From: Robert Findlay
Sent: 31 July 2009 11:44
To: Planning.Responses
Subject: FW: Planning Consultation on: LU/190/09/

APPLICATION NO: LU/190/09/

Registered: 15-JUL-09
Site Address: Littlehampton Coastguard Tower The Promenade Arun Parade
Littlehampton BN17 5LL

Description of Works: Proposal to convert a redundant coastguard tower to a residential property to include a change of use.

DRAWING SCALE
Proposed Floor Plans, Elevations & Section As Noted

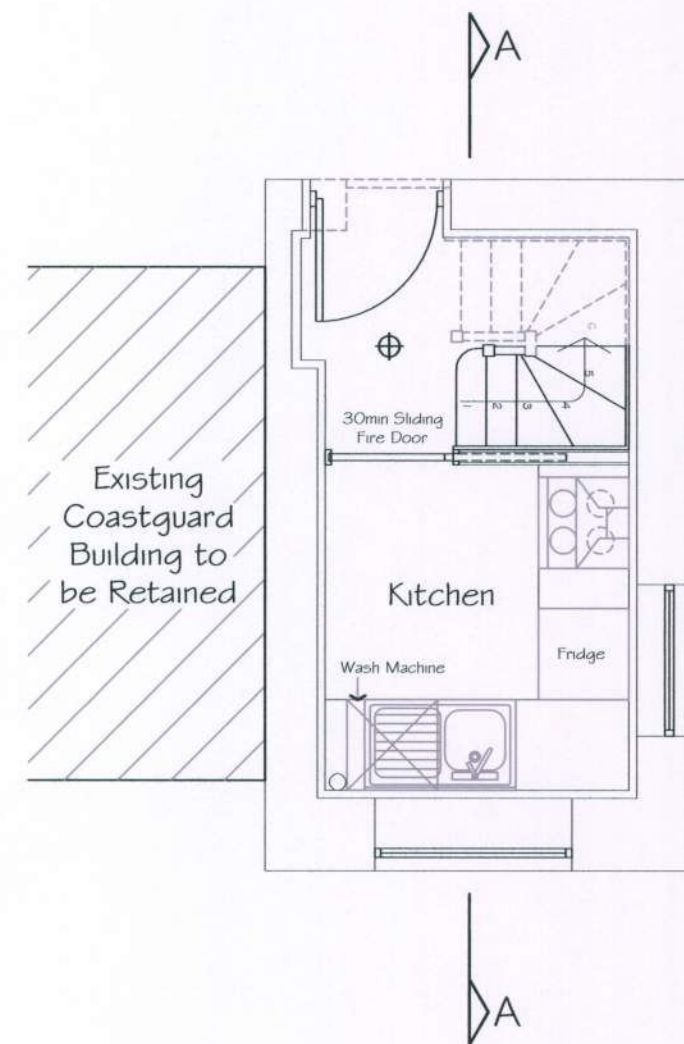
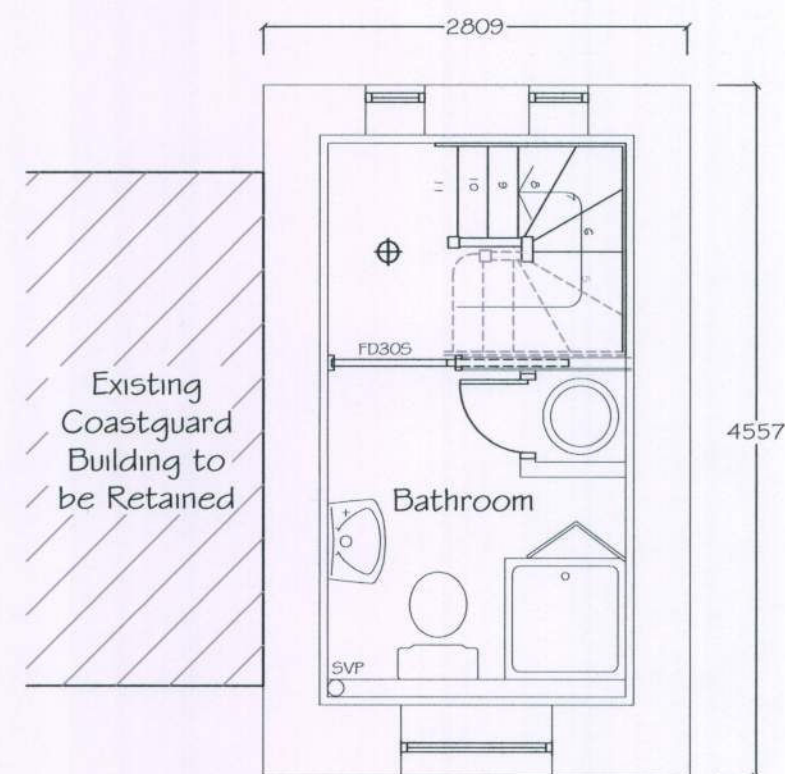
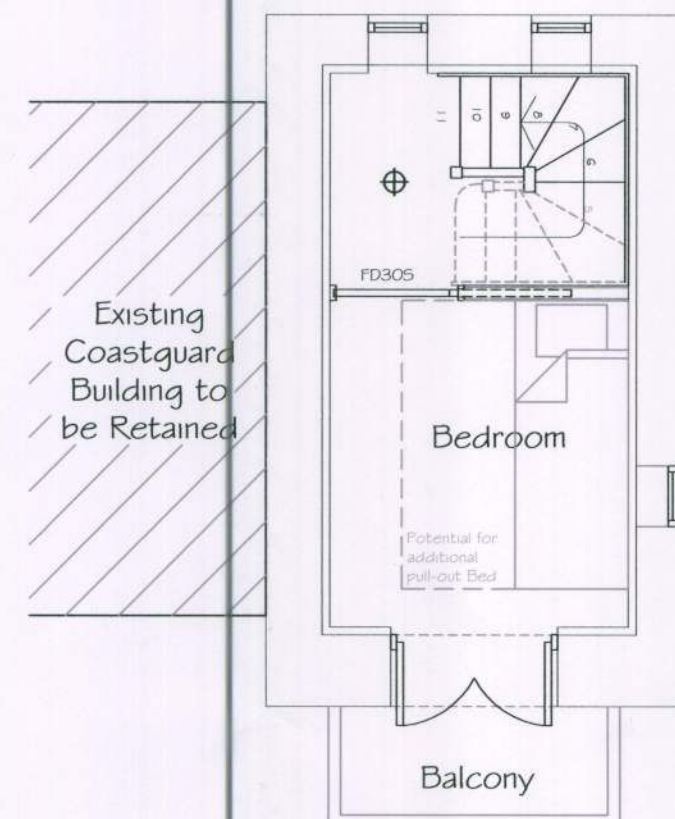
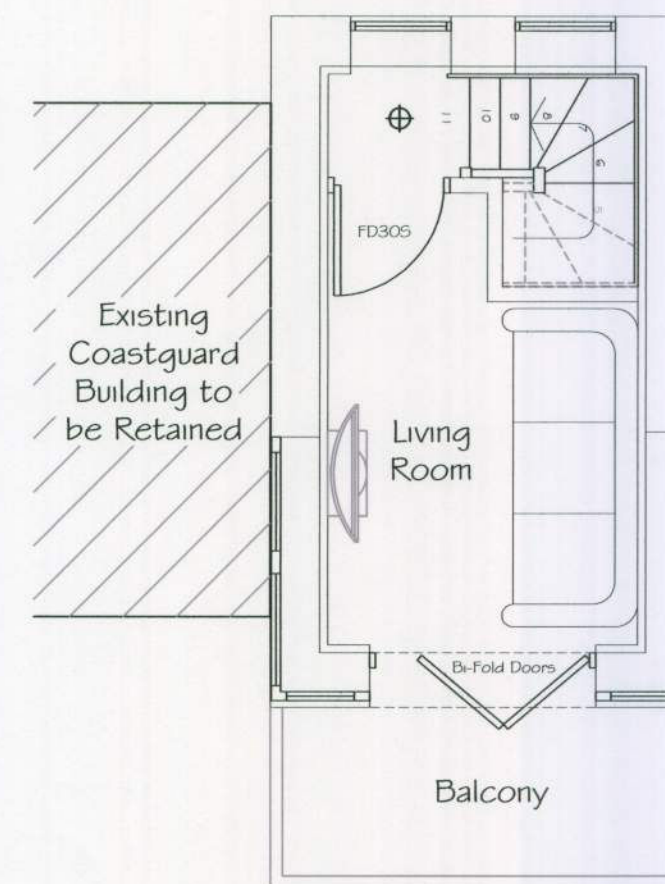
The room sizes appear to be too small. for the private rented market

A one bedroom dwelling should have a living room of 11.5 sq m a bed room of 7 sq m and a kitchen of 5.5 sq m for 2 persons the room sizes are 10.5 sq m for the bedroom and 13 sq m for the living room.

If the property comes onto the private rented market and is occupied the local authority may serve Housing Act Notices/orders to restrict the occupancy.
